Date 2/08/2021
To Chris Ritchie
From Sean Fishwick
Copy to Sheelagh Laguna, Luke Parker, Jordan Rodgers, Anthea Gilmore, Kristen Branks
Subject Kings Park Expansion SSD – Response to DPIE Submission

The Kings Park Metal Recycling Expansion (SSD-10396) Environmental Impact Statement (EIS) was submitted for exhibition on 17th September 2020 and has entered the response to submission phase. A submission was received from the Department of Planning, Infrastructure and Environment via email on 6th November 2020. The submission comments and responses to each have been provided in the table below.

B1 SHEET

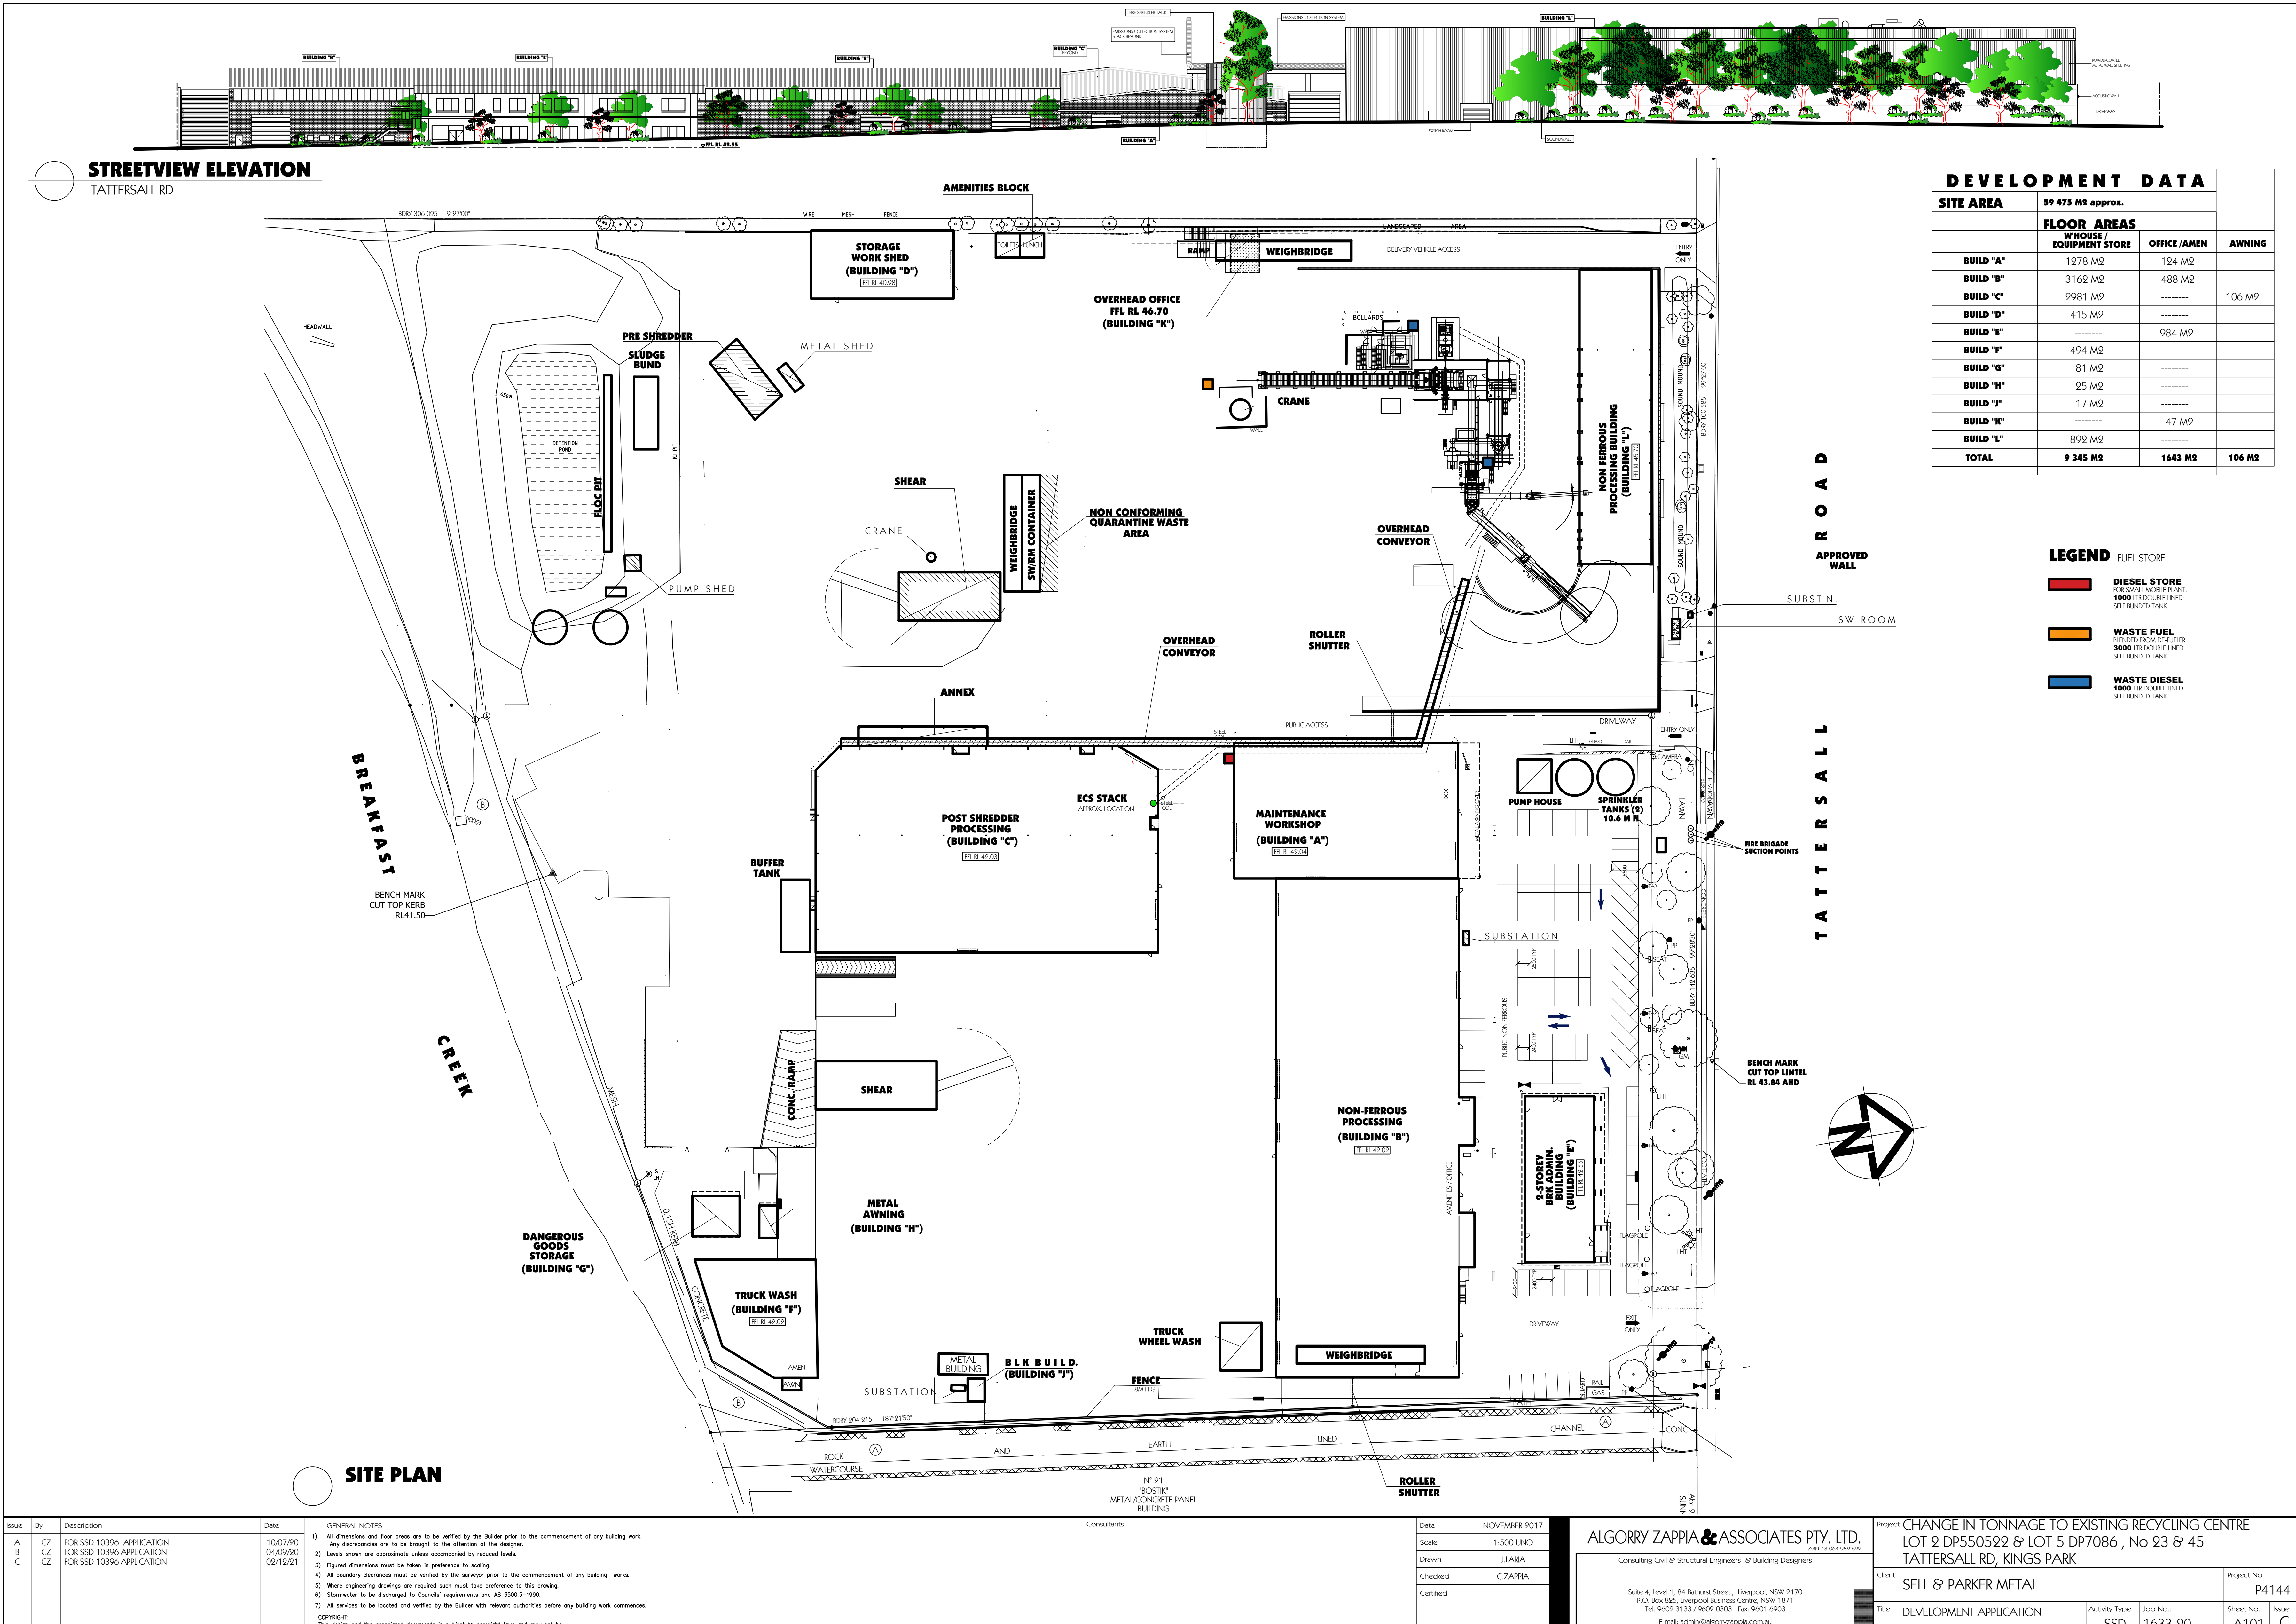
<ul style="list-style-type: none"> Please show and label all plant, including those in buildings, on the site plan. 	Plant labels on site plan	<p>The Site Layout Plan (Appendix C of the EIS) is intended to display the plant and equipment at a high level. Further details are provided in Figure 2-3 of the EIS which has been revised and updated to include labels for plant and equipment within buildings and is included as Appendix F of the RtS.</p> <p>A description of the plant and equipment is provided in Section 2.4 of the EIS. Specifics of the layout and processes for individual items of processing plant are commercial in confidence and as such have been excluded from the EIS. Specific details and schematics can be provided to DPIE separately on a strictly commercial in confidence basis, if required.</p>

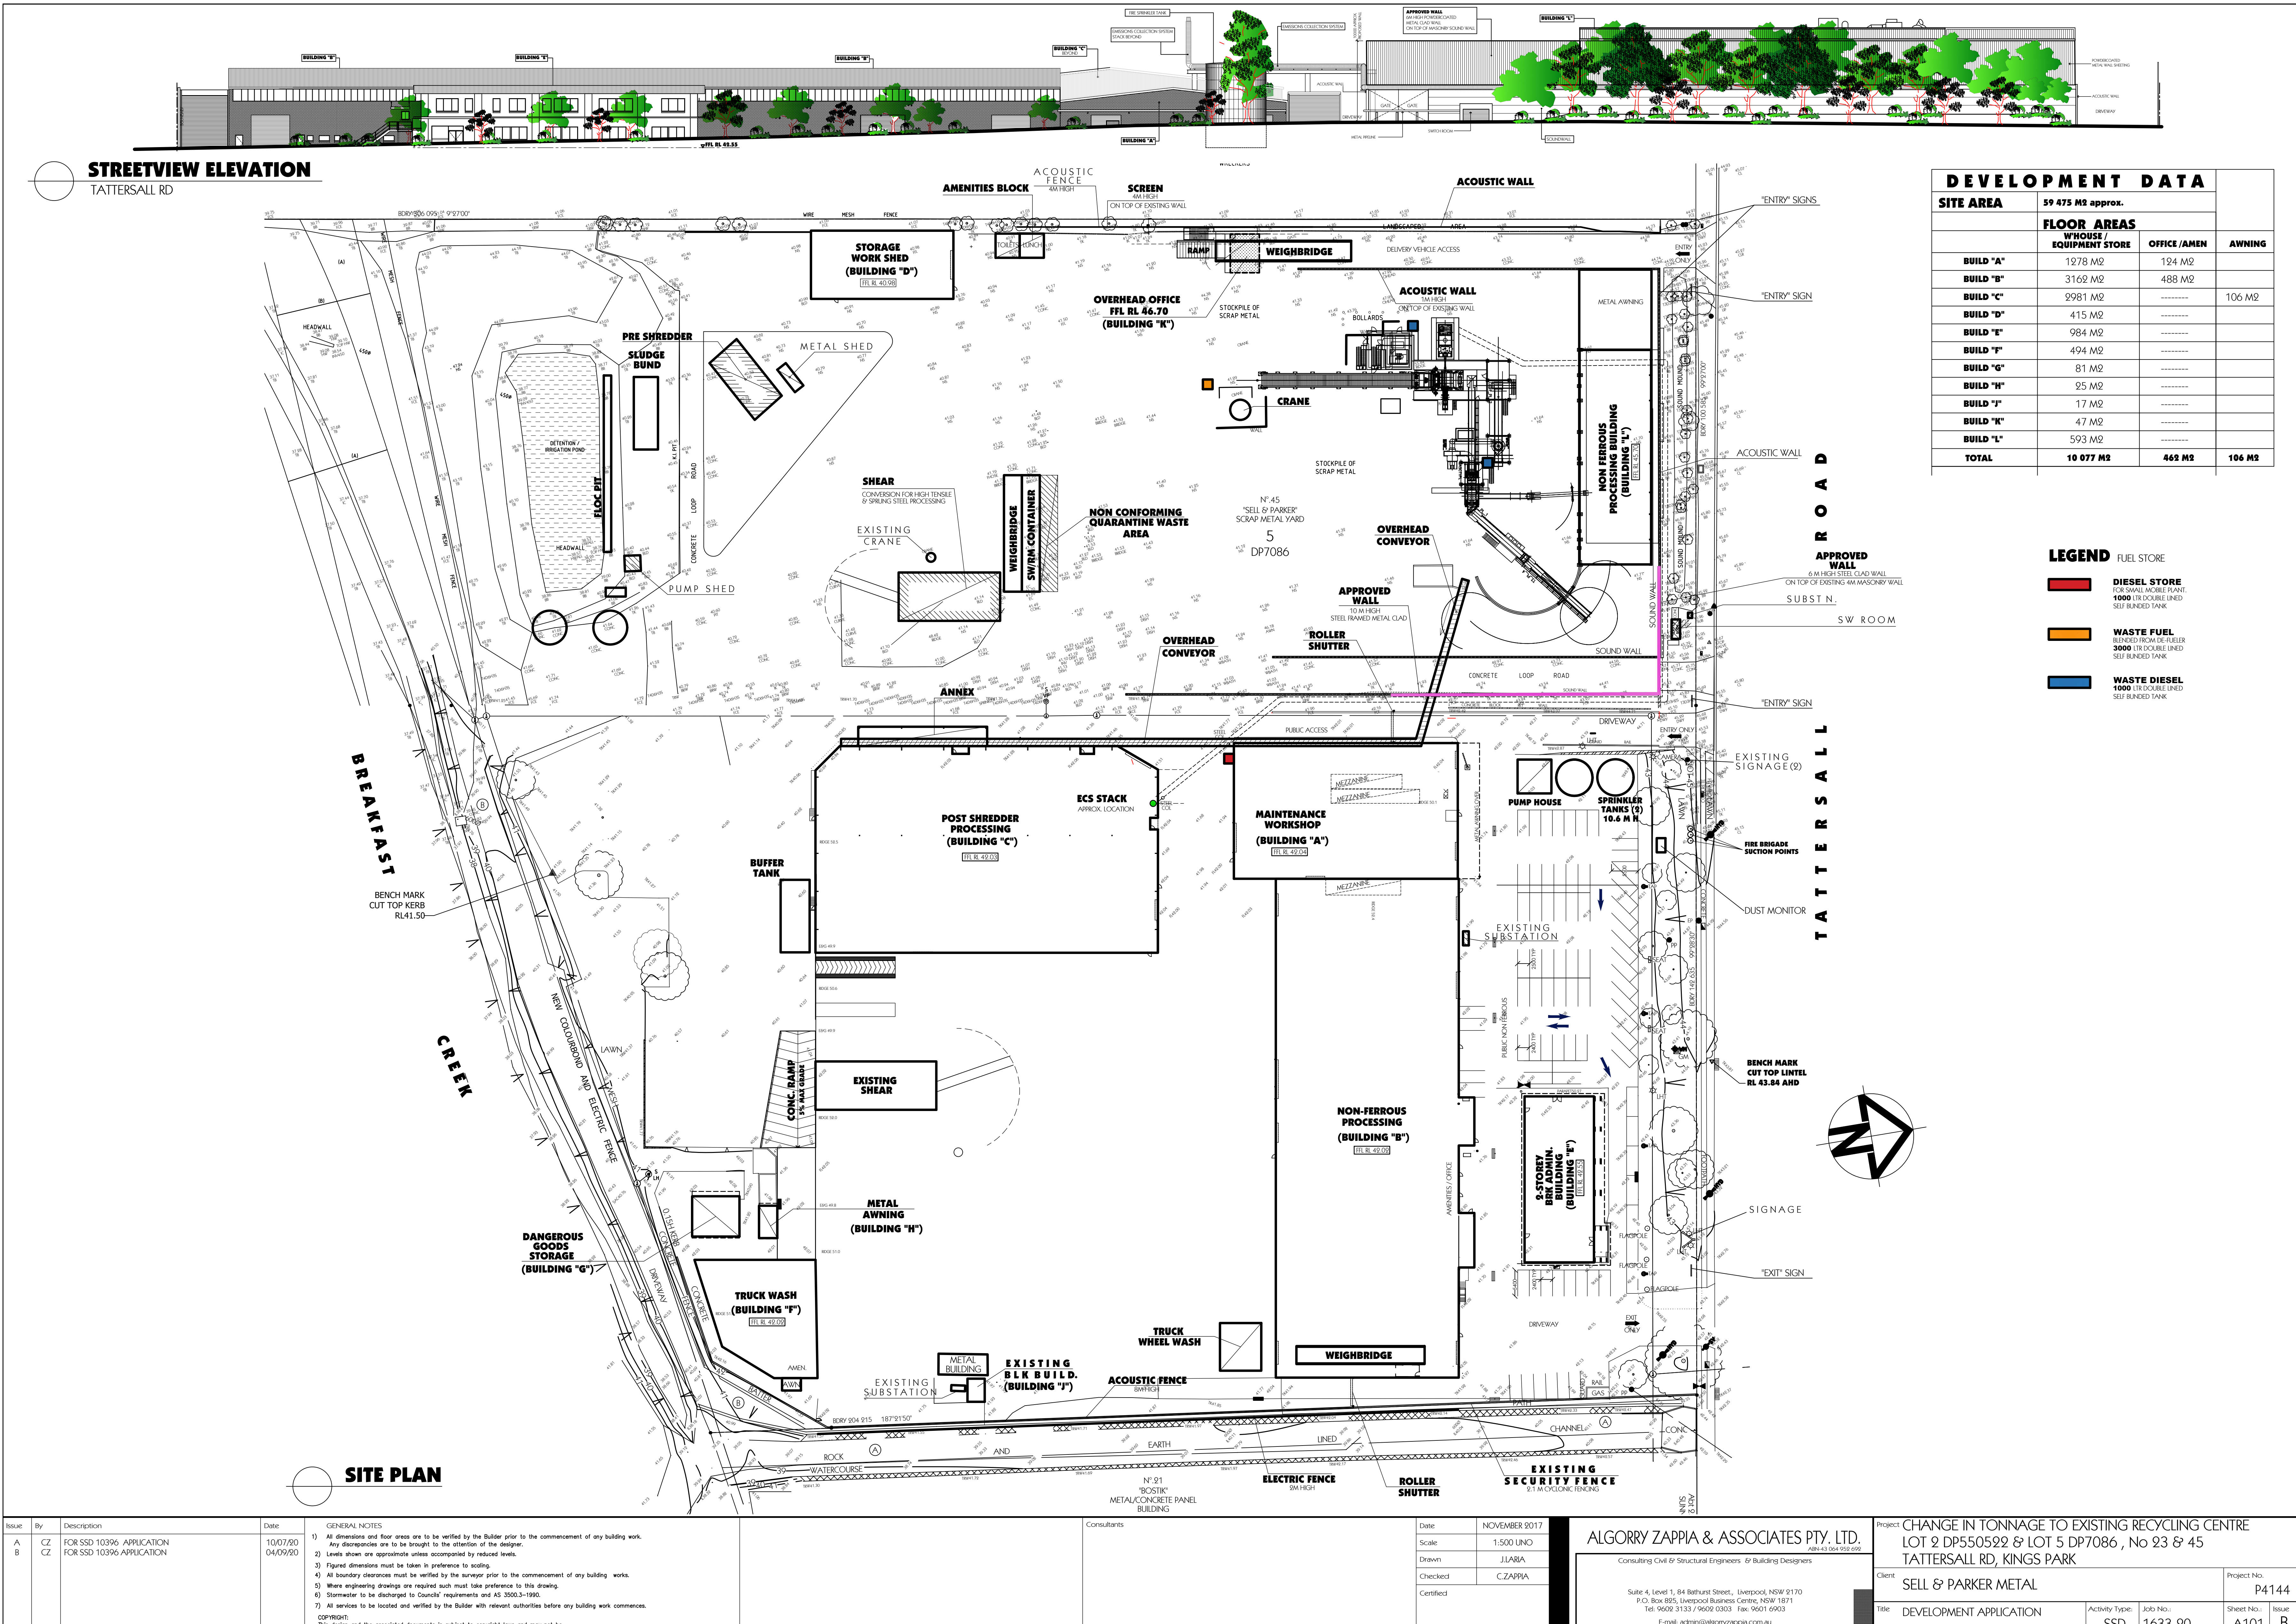
<ul style="list-style-type: none"> It is stated in the EIS that stockpile volumes would not increase as a result of this development. Please confirm what measures would be put in place to monitor stockpile size and ensure the volumes remain the same as approved by SSD-5041 MOD 3. 	Stockpile Volumes	<p>The Stockpile Plan presented in Appendix D of the EIS detailed the locations and volumes of combustible stockpiles located within the Proposal site and has subsequently been amended. A revised stockpile plan is provided as Appendix G of the RtS and is identical to the plan under SSD5041 Mod 3.</p> <p>The nature of scrap metal recycling is such that the volume of inputs (i.e. scrap metal loads arriving at site) fluctuate across the day, week and year. As per existing approved operations, processing activities such as sorting of scrap in tipping areas, loading of scrap into processing equipment will be managed to maintain scrap metal stockpiles</p>

Comment	General Topic	Response
		<p>within the currently approved limits identified on the revised stockpile plan (Appendix G of the RtS).</p> <p>Sell & Parker aims to clear tipping areas of combustible scrap metal stockpiles (by processing this material) prior to close of business each day with any remaining material sorted into the numbered stockpiles on the plan. It should be noted that there are 14 stockpiles (including the Floc stockpile) for combustible material illustrated on the plan but not all of these stockpiles contain material or are used simultaneously. The stockpile management plan provides sufficient capacity for maintaining the stockpile management at the end of daily operations. During operations the Floc stockpile continues to be managed by ongoing offsite disposal (daily basis) and the working pile would continuously be processed.</p> <p>Similarly, product stockpiles (e.g. shred, aluminium) are managed on an ongoing basis through scheduling of pickups (for offsite re-use, recovery or disposal) or sale to customers (e.g. Steel mills). As described in section 3.4 of the EIS, a capacity analysis was prepared for the Proposal that identified sufficient capacity was available within the existing processing equipment to accommodate the proposed increased throughput.</p>
